Re: Block 2 & 2A PA – Council Letter 17/11/09

**NORTH/EAST
FACADE DETAIL**

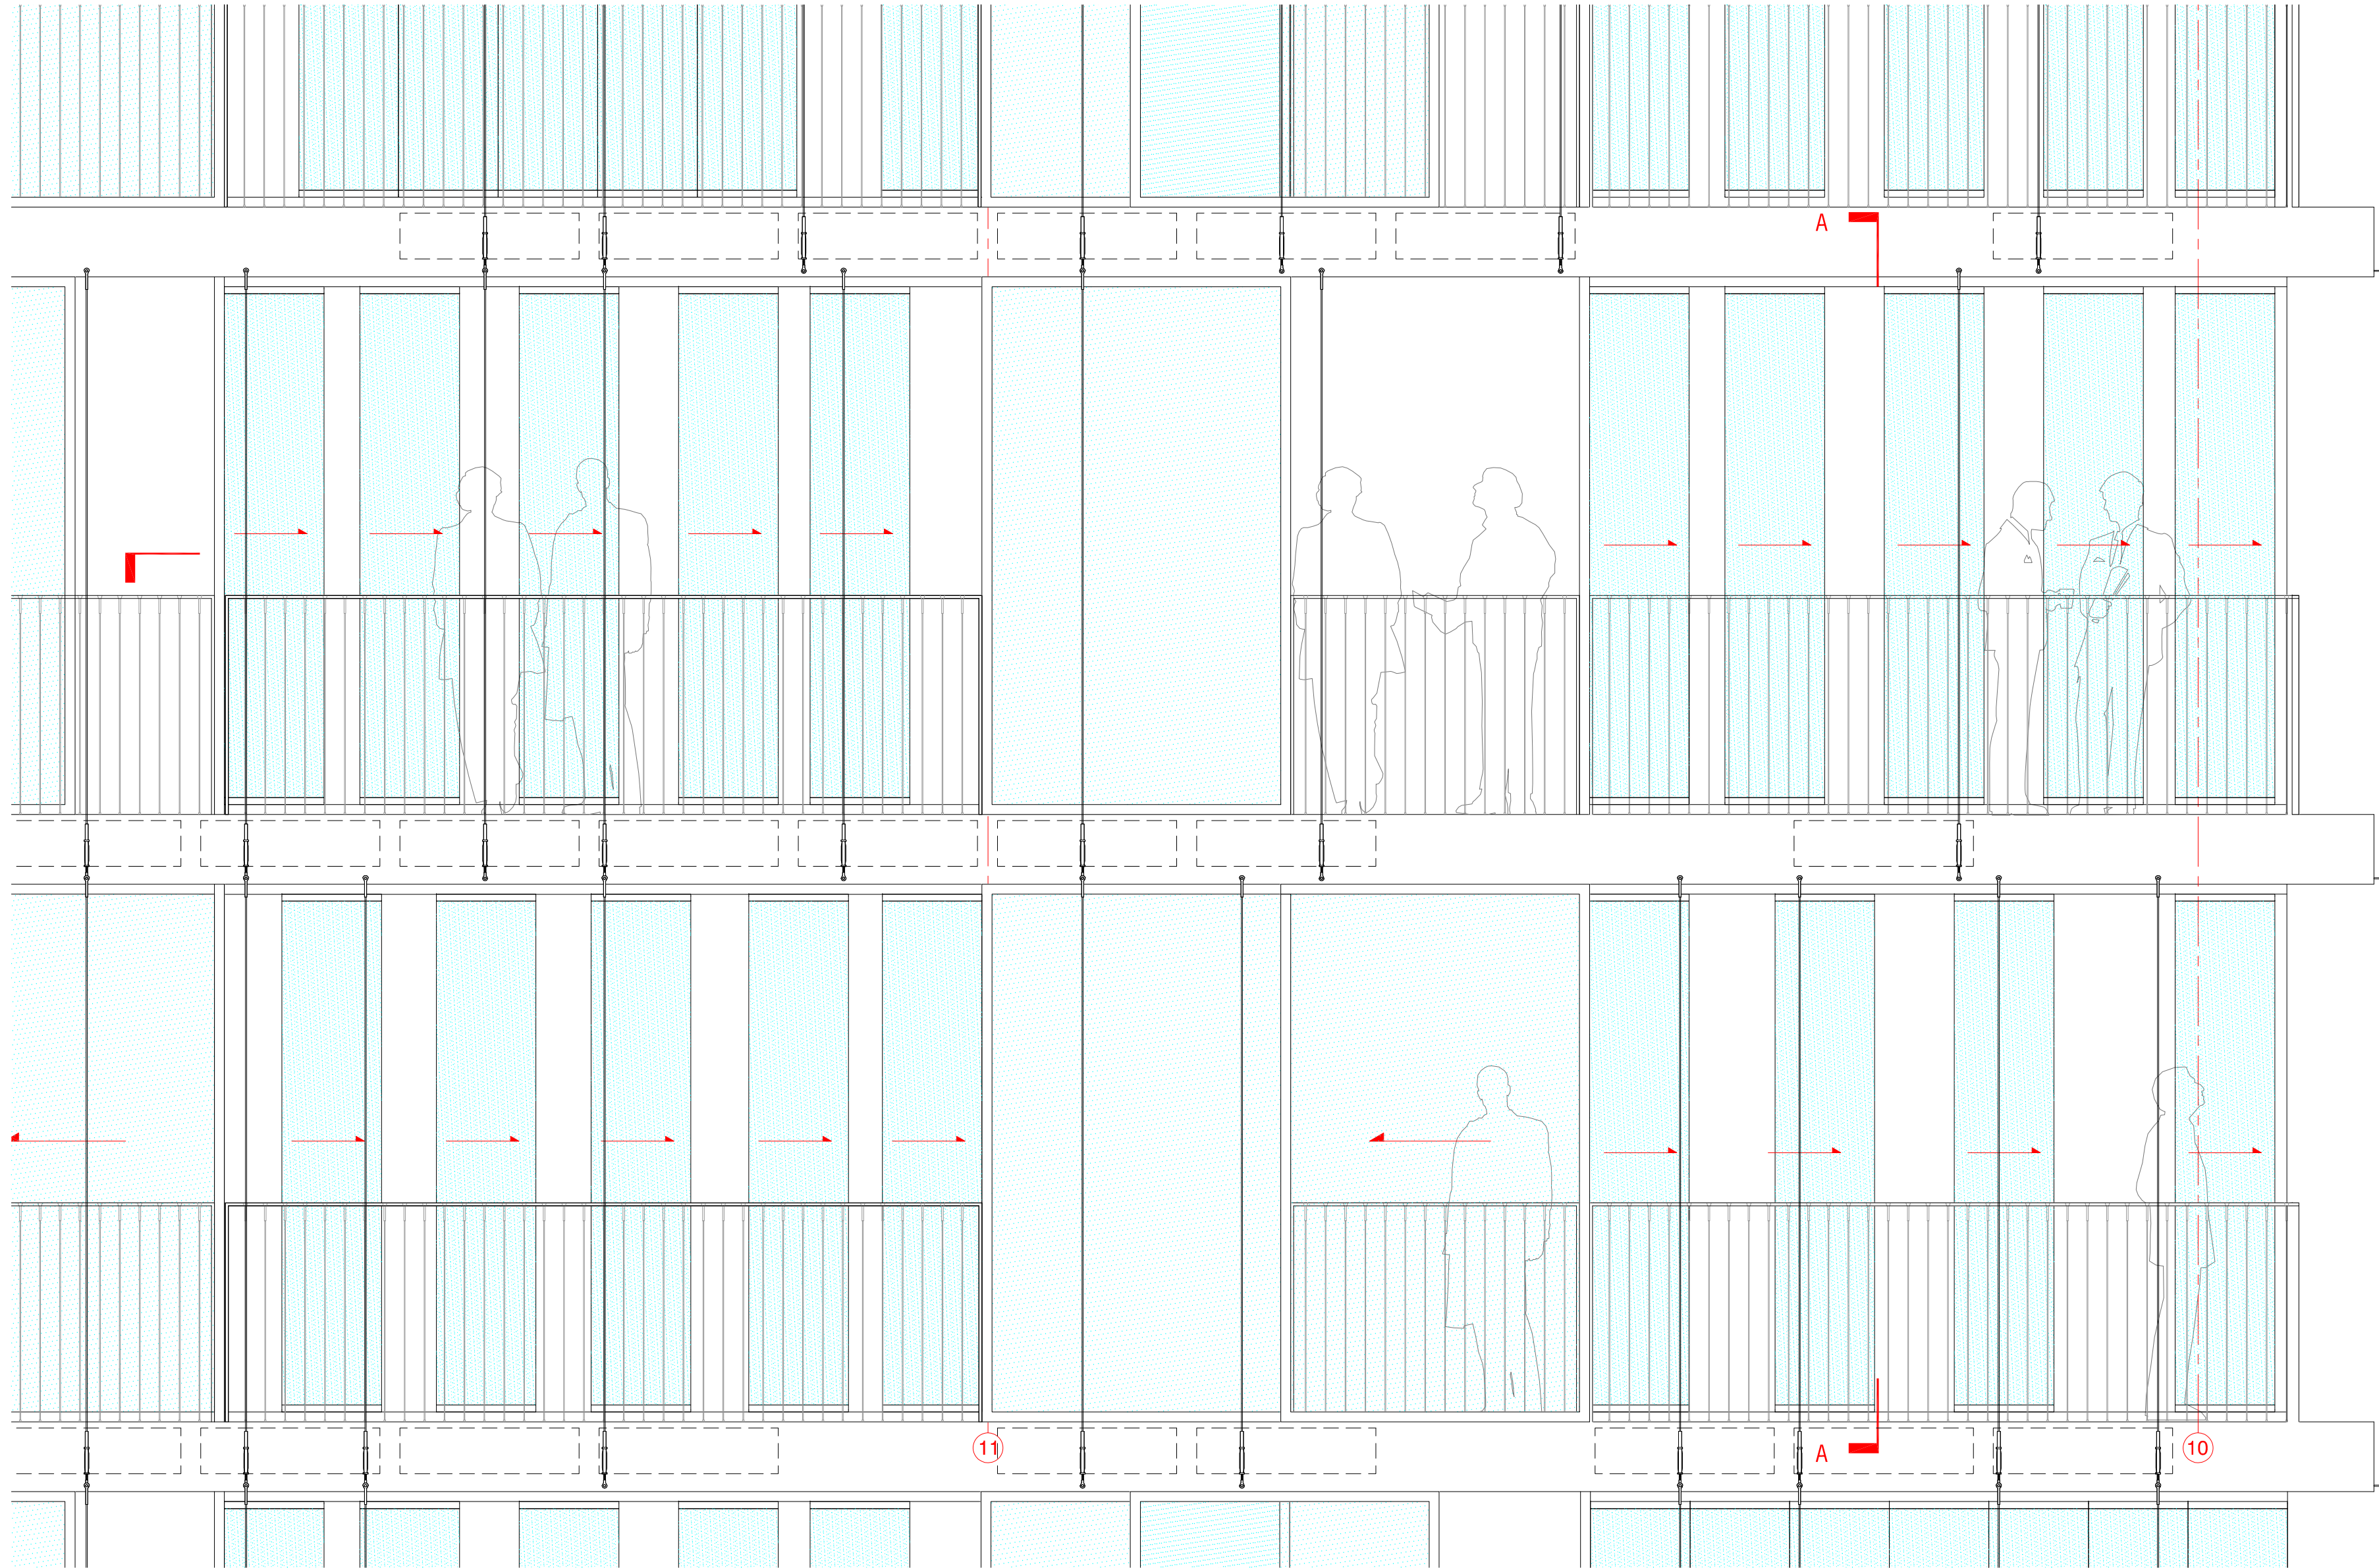
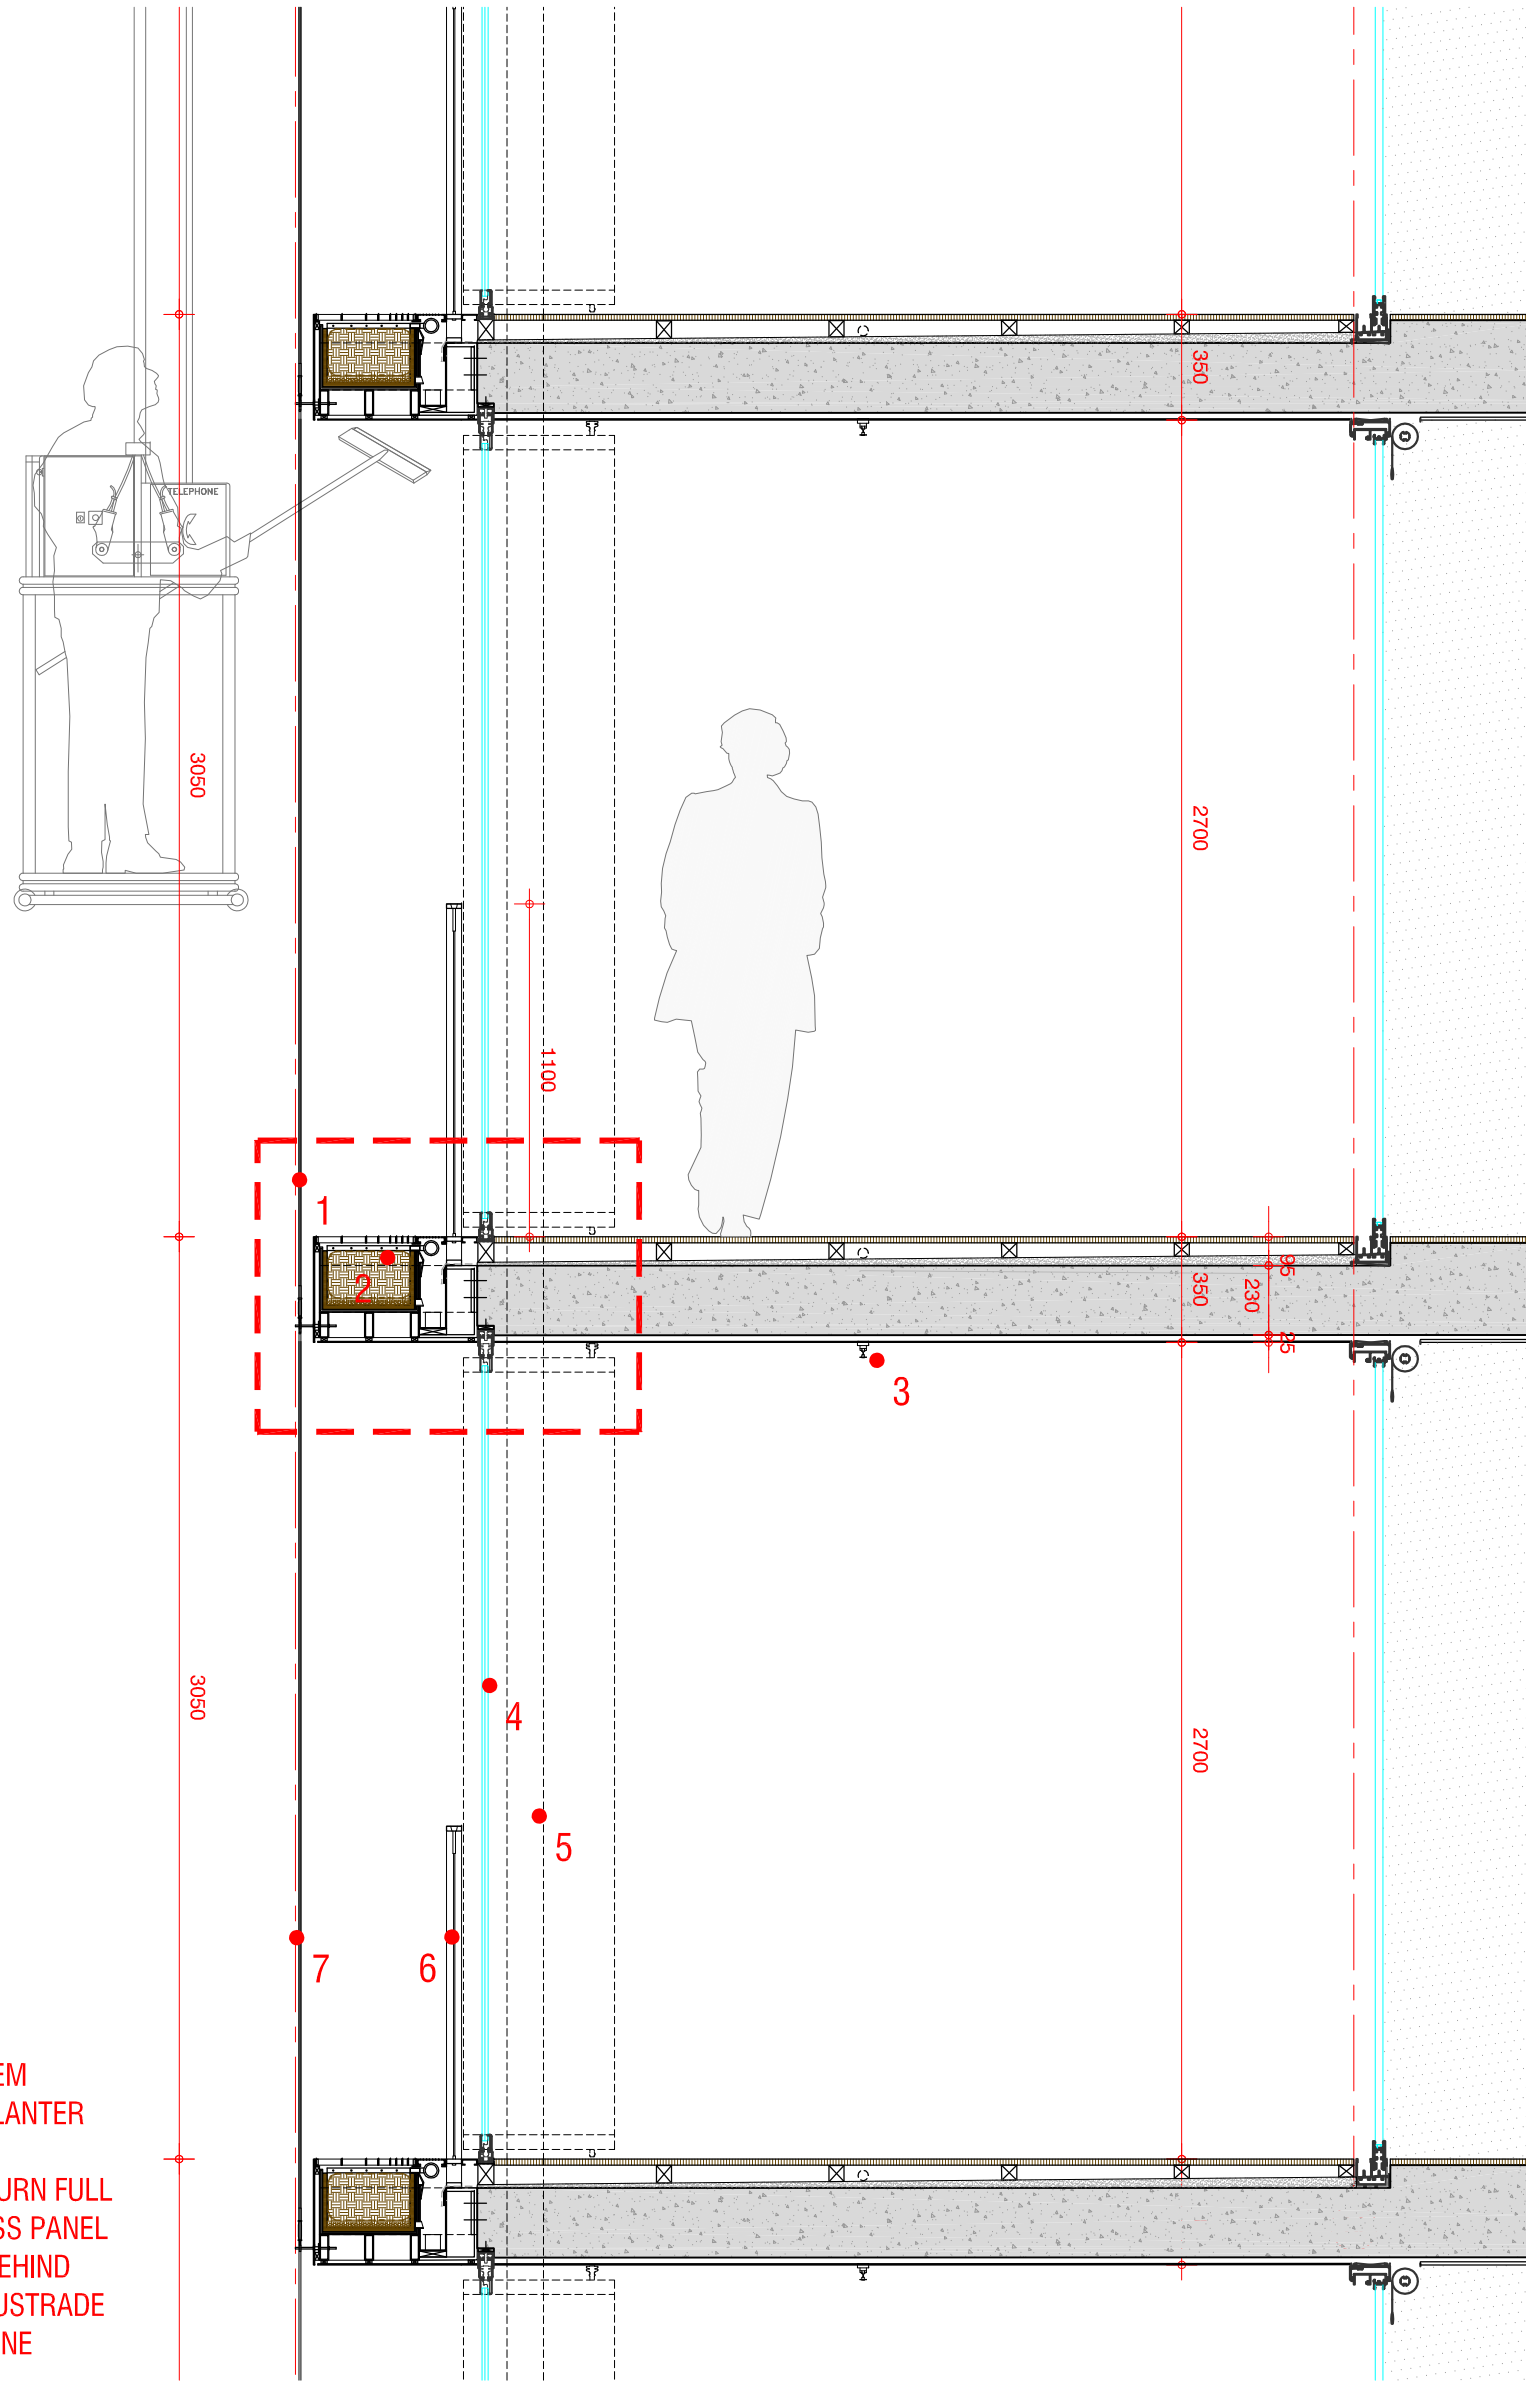
Area 2a terraces / connection to the Main Park			These issues are dealt with in the PPR
LANDSCAPE				
Pt1	Façade Planting	SCC		AJN have submitted images with the vines and planters stripped off. They have commented within the PPR regarding similar comments. Patrick Blanc's vegetal wall has been prototyped at Trio and the remaining work will be progressively prototyped with the display building. The PPR has commented on the maintenance costs.
SIGNAGE				
Pt1	Façade signage zones	SCC	Separate Signage DA	Arch/Client To suit base building construction provisions.
Pt2	Childcare Location and Details	SCC		This is responded to in the body of the PPR.
